Civil / Stormwater Responses to SSD 6962 BCC Conditions – 60 Wallgrove Road, Eastern Creek

Further to our meeting with you on the 28th of September, please find below a detailed summary of the points raised by Council in your letter dated 7th September 2015.

No.	Proposed Condition	AT&L / Mirvac Comments
2.7.1	Amended drainage plans from AT&L consultants (reference 12-108, revision B dated 28 May 2015) are to be provided to meet the requirements under Council's DCP Part R 2006 and Councils Engineering Guide for Development 2005. The amended plans must address the following:	Condition accepted – No changes proposed.

Civil Engineers and Project Managers		
Suite 702, 154 Pacific Hwy St Leonards NSW 2065 ABN 96 130 882 405 Tel: 02 9439 1777 Fax: 02 9460 8413 www.atl.net.au info@atl.net.au		
Status	FOR APPROVAL NOT TO BE USED FOR CONSTRUCTION	A1
Drawing No.	DAC038	Issue
Project No.	12-108	B

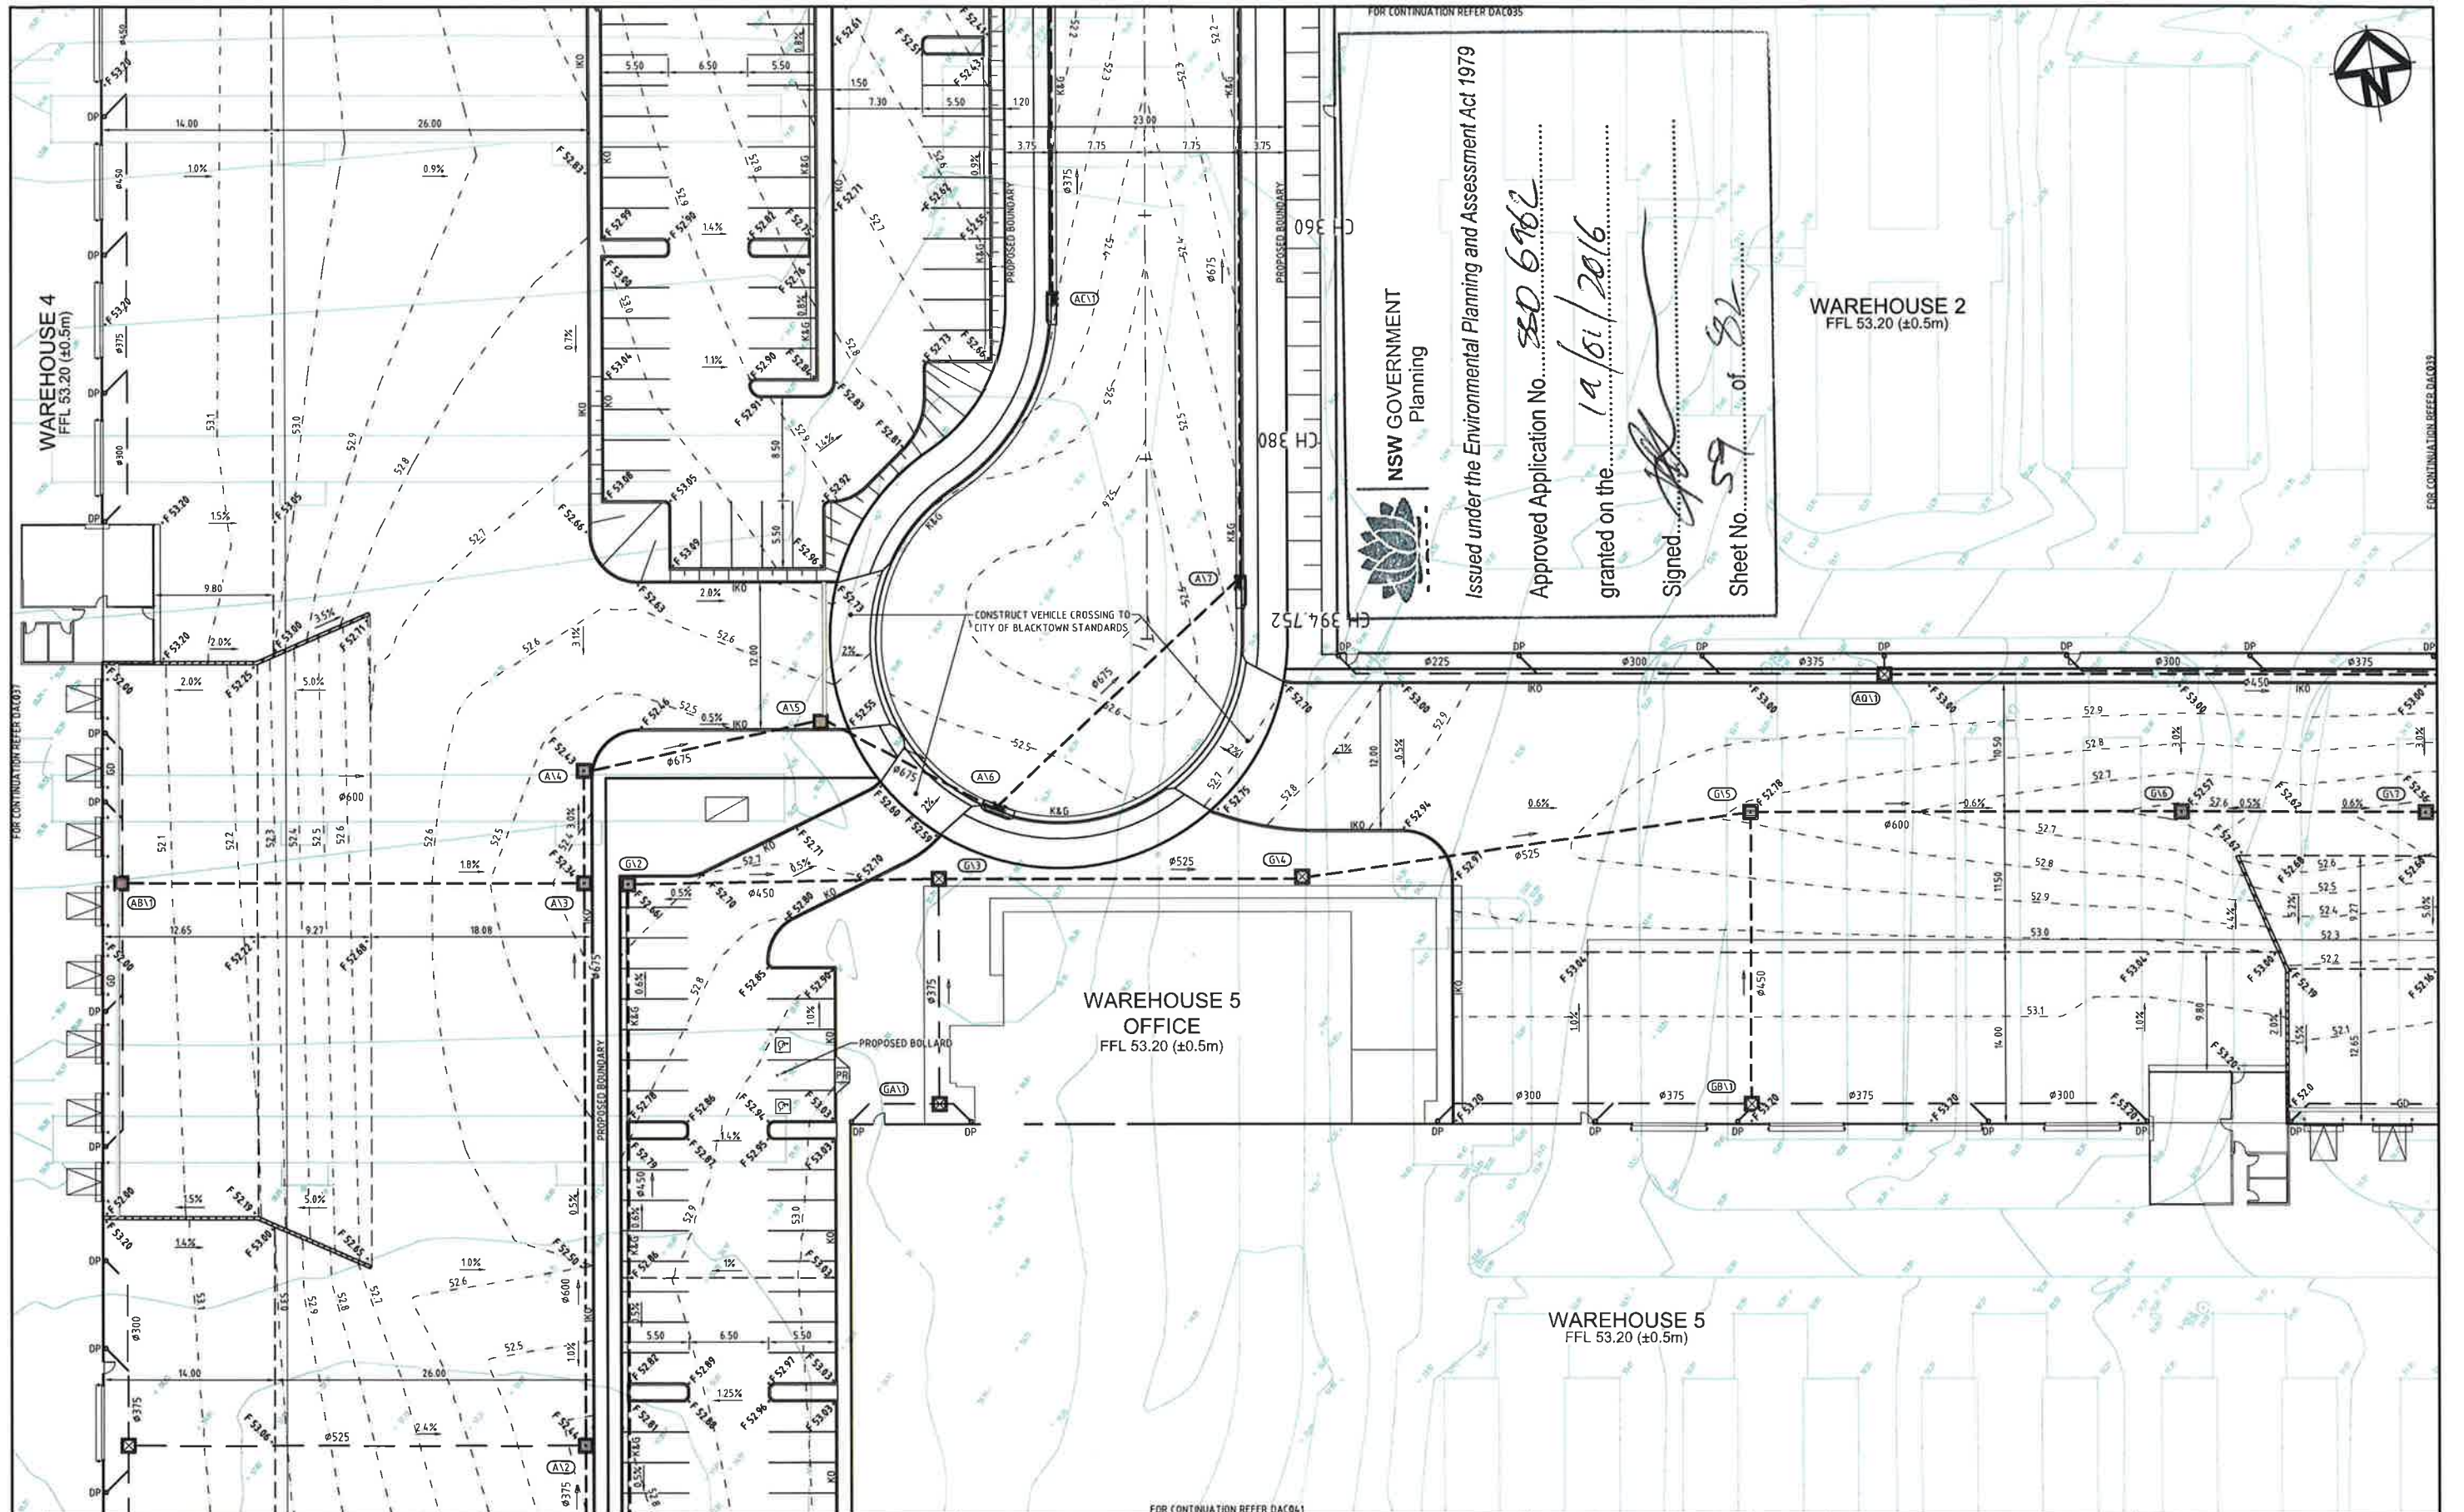
2.7.1 (xii)	On plan DAC038 reconfigure the drainage for 50% of roof water to discharge direct to the rainwater tanks and not to the surface drainage system, except for the south west corner of warehouse 4 which discharges to the Eastern catchment.	To be deleted. Refer to new clause 7.1.12. 2.7.12	OK

Status	FOR APPROVAL NOT TO BE USED FOR CONSTRUCTION	A1
Drawing No.	DAC036	Issue
Project No.	12-108	B

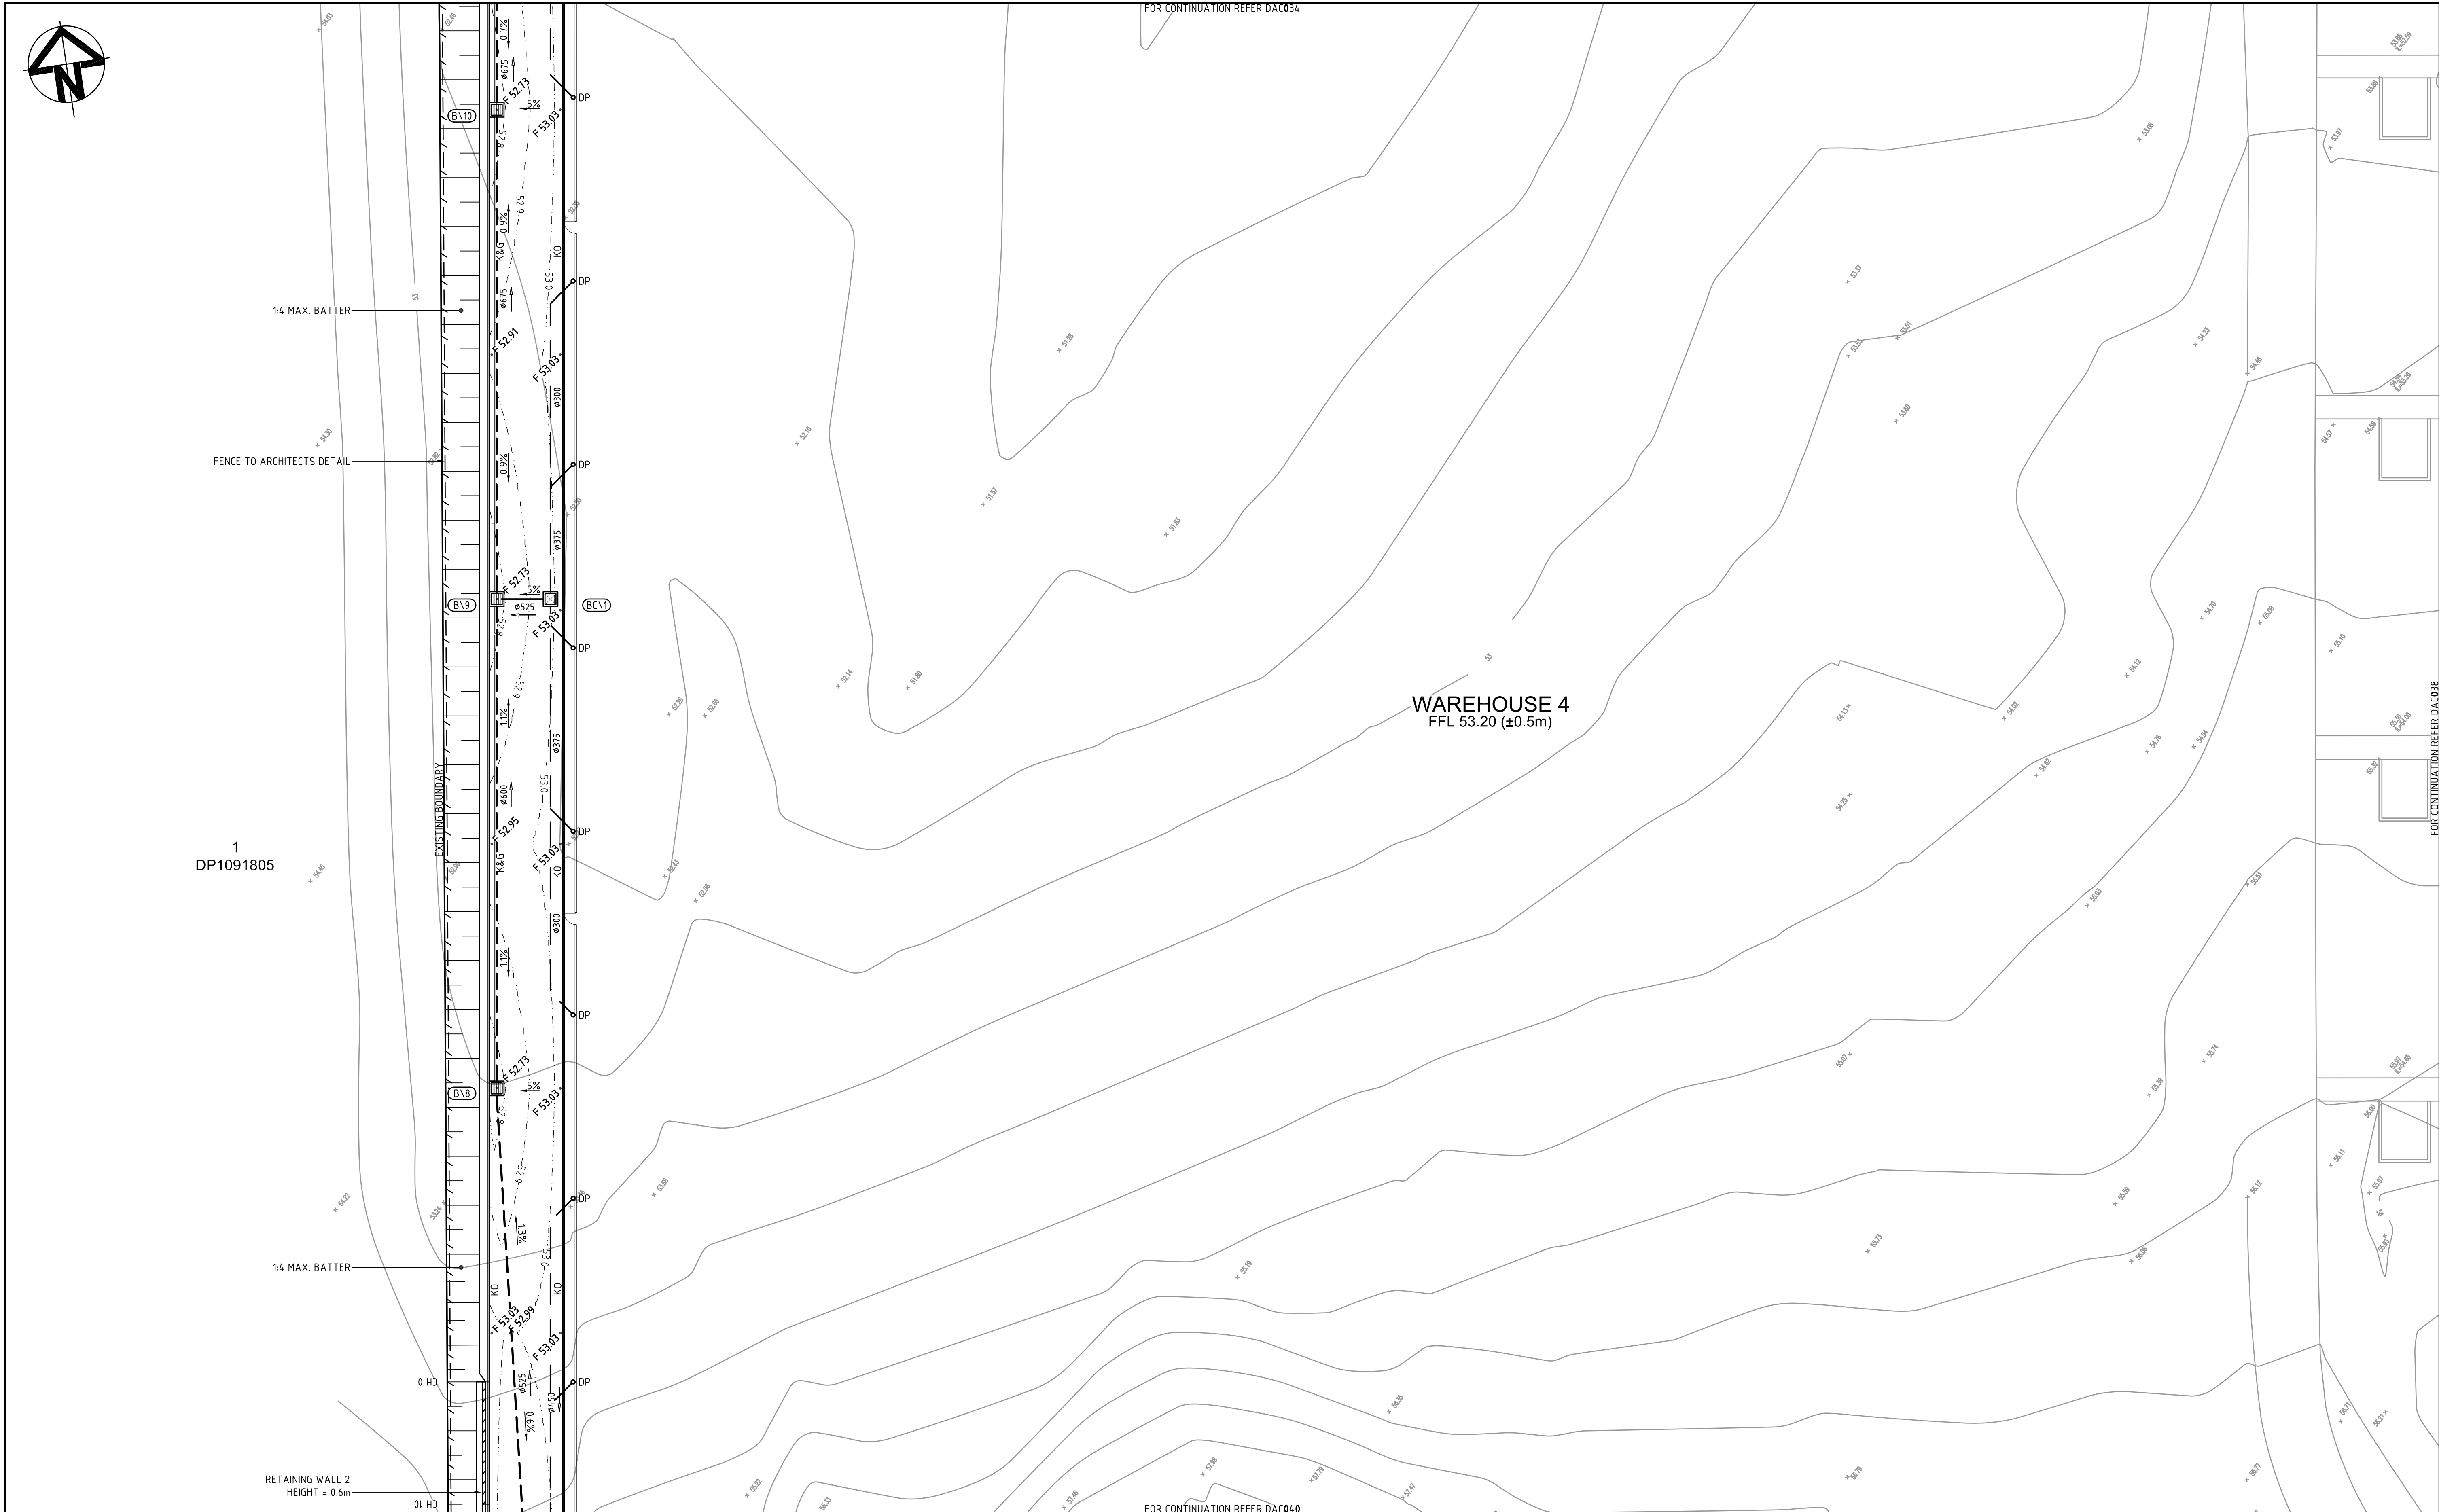
2.7.1 (x)	On plan DAC036 — reconfigure the drainage for 50% of roof water to discharge direct to the rainwater tanks and not to the surface drainage system. - provide the GPT downstream of pit A\20 and show eductor access location. - provide a minimum 400 mm deep sump pit immediately downstream of the proposed GPT's prior to discharging into the basin. Scour protection to still be provided at outlet into basin. Raingarden-Sediment Forebay (concrete base with seepage holes) as part of the scour protection at A\21. - provide a minimum 3 m wide concrete vehicular accessway at maximum 10 % grade down to the northern end of bioretention basin to allow for maintenance.	To be deleted. Refer to new clause 7.1.12. 2.7.12 Condition accepted – No changes proposed Clause amended as discussed. Condition accepted – No changes proposed	OK OK OK for changes subject to pit 1500x1500 minimum OK

DAC042

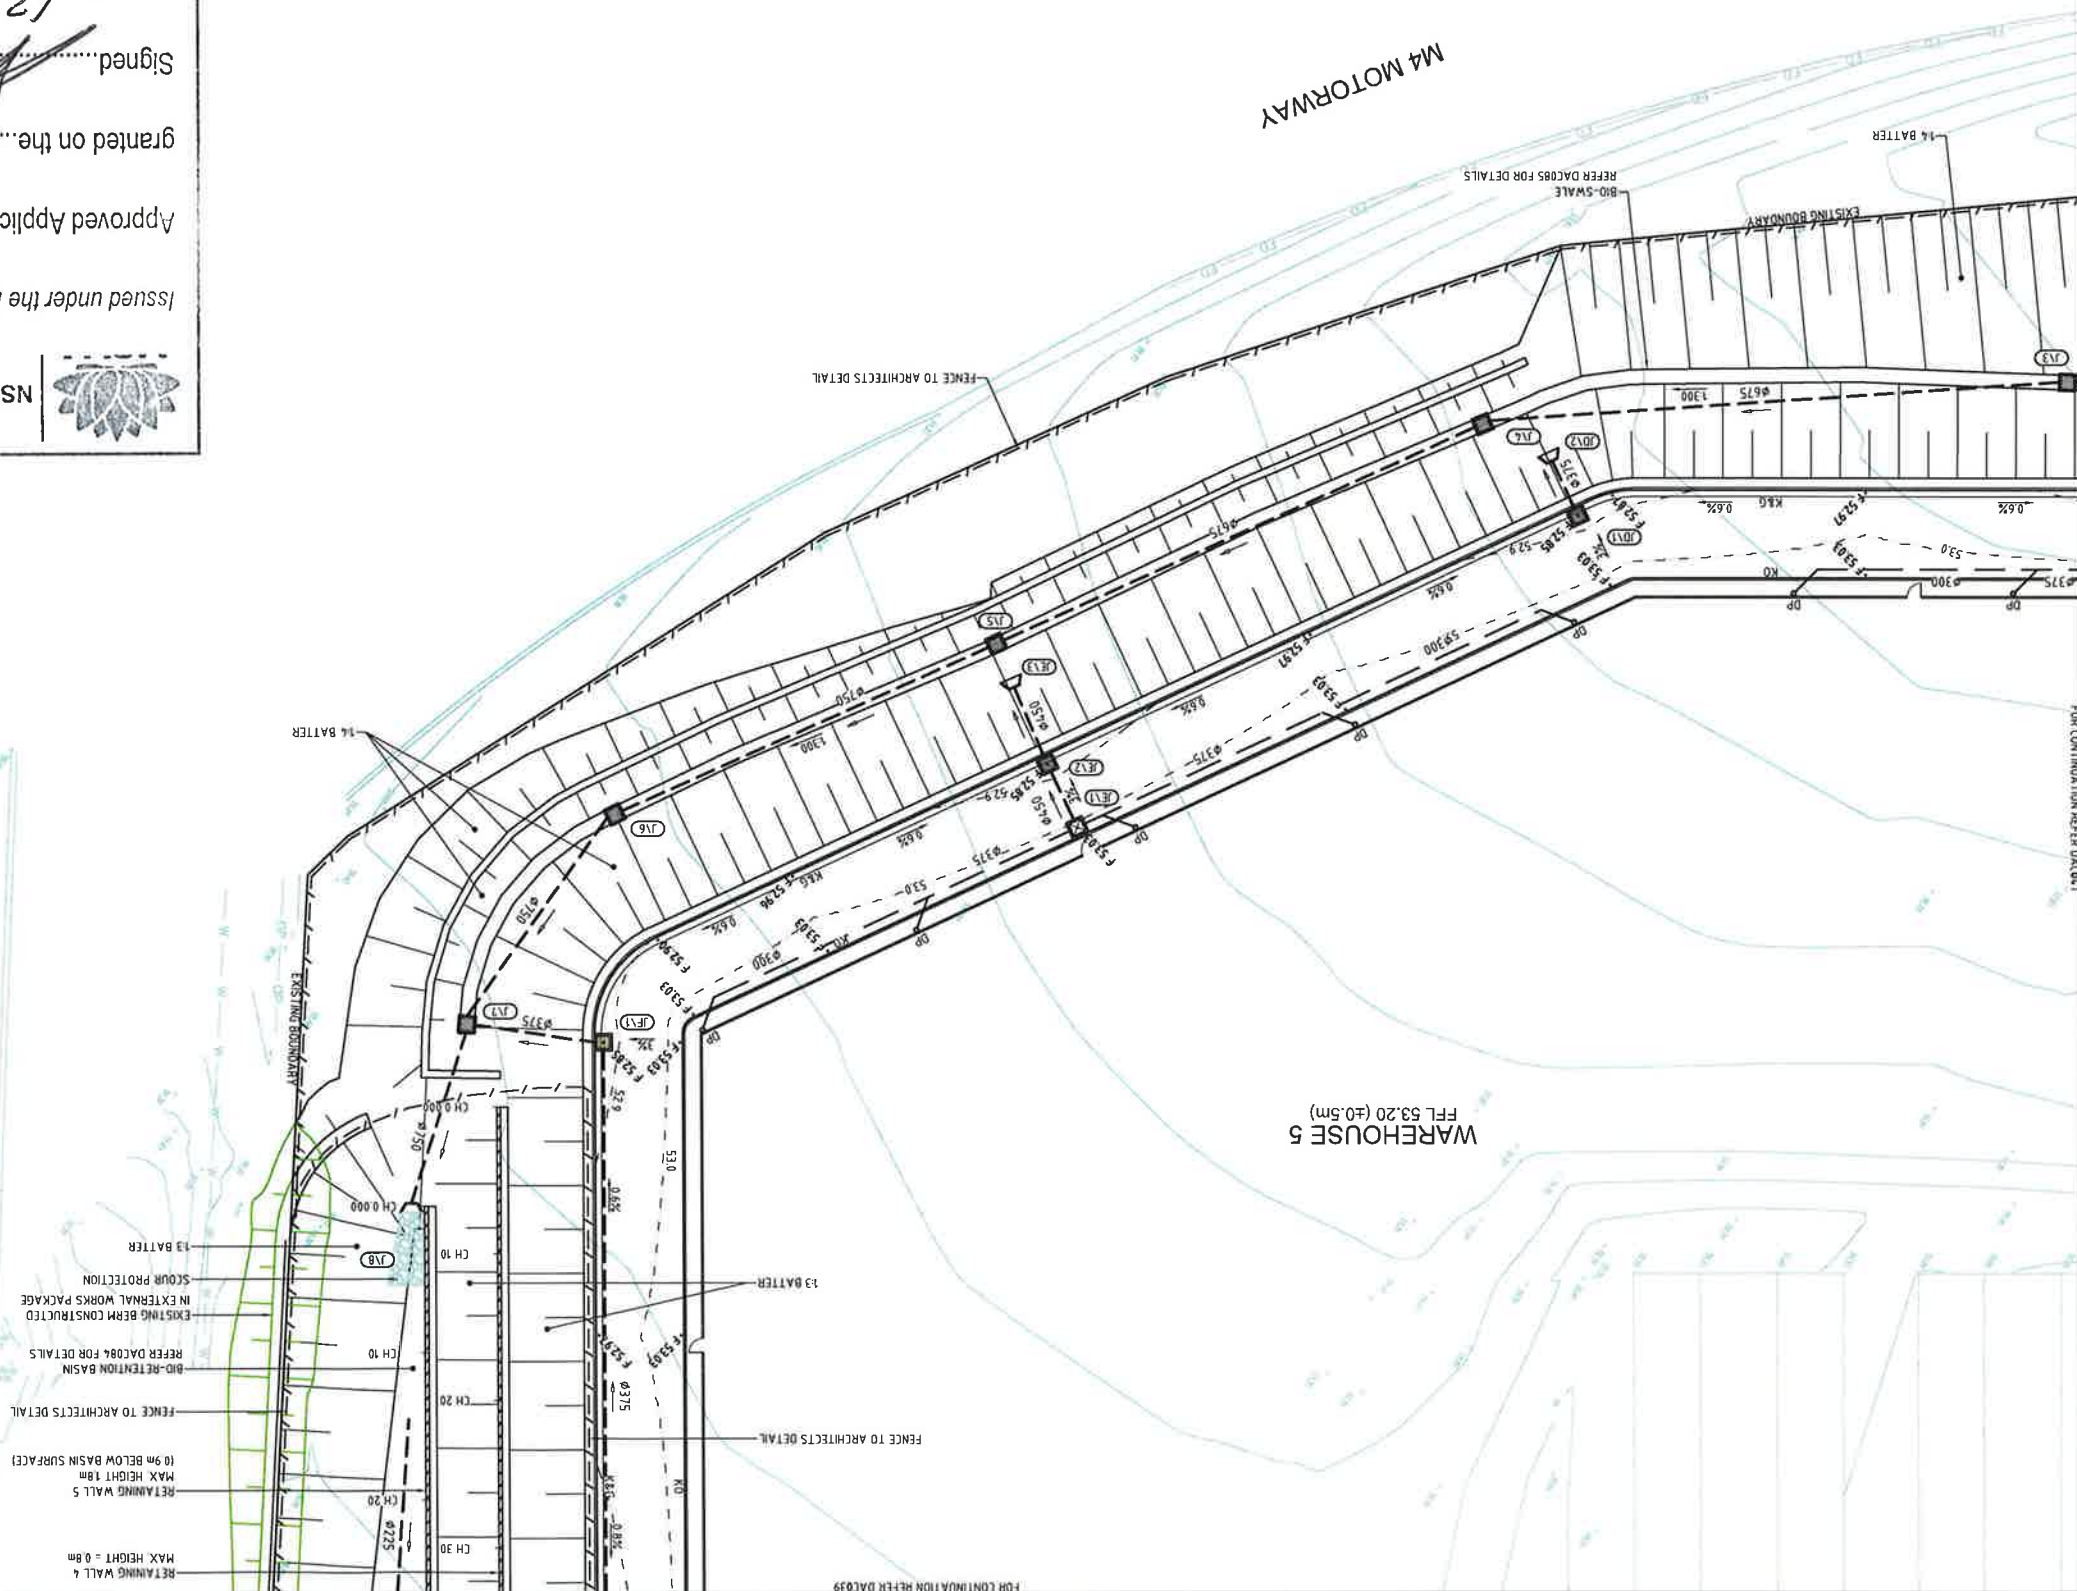
2.7.1 (xv)	<p>On plan DAC042</p> <ul style="list-style-type: none"> -reconfigure the drainage for 50% of roof water to discharge direct to the rainwater tanks and not to the surface drainage system. -provide for gaps in the kerbs adjacent to the bioretention swale. Ensure a minimum of 35% openings in the kerb. -provide jute mat and dense planting over the batter slope to resist scour. -extend the scour protection for each piped outlet (if required) down to the swale. -provide a minimum 400 mm deep sump pit immediately downstream of pit J/7 prior to discharging into the basin. Scour protection to still be provided at outlet into basin. Raingarden Sediment Forebay (concrete base with seepage holes) as part of the scour protection at J\7. -provide a minimum 3 m wide concrete vehicular accessway at maximum 10 % grade down to the southern end of bioretention basin to allow for maintenance. 	<p>To be deleted. Refer to new clause 7.1.12.</p> <p>2-7-12</p> <p>To Be Deleted</p> <p>To Be Deleted</p> <p>To Be Deleted</p> <p>To Be Deleted</p> <p>Clause amended as discussed.</p> <p>To Be Deleted</p>	<p>OK</p> <p>OK</p> <p>OK</p> <p>OK</p> <p>OK with pit J/7 increased to 1500 x 1500 minimum</p> <p>OK</p>
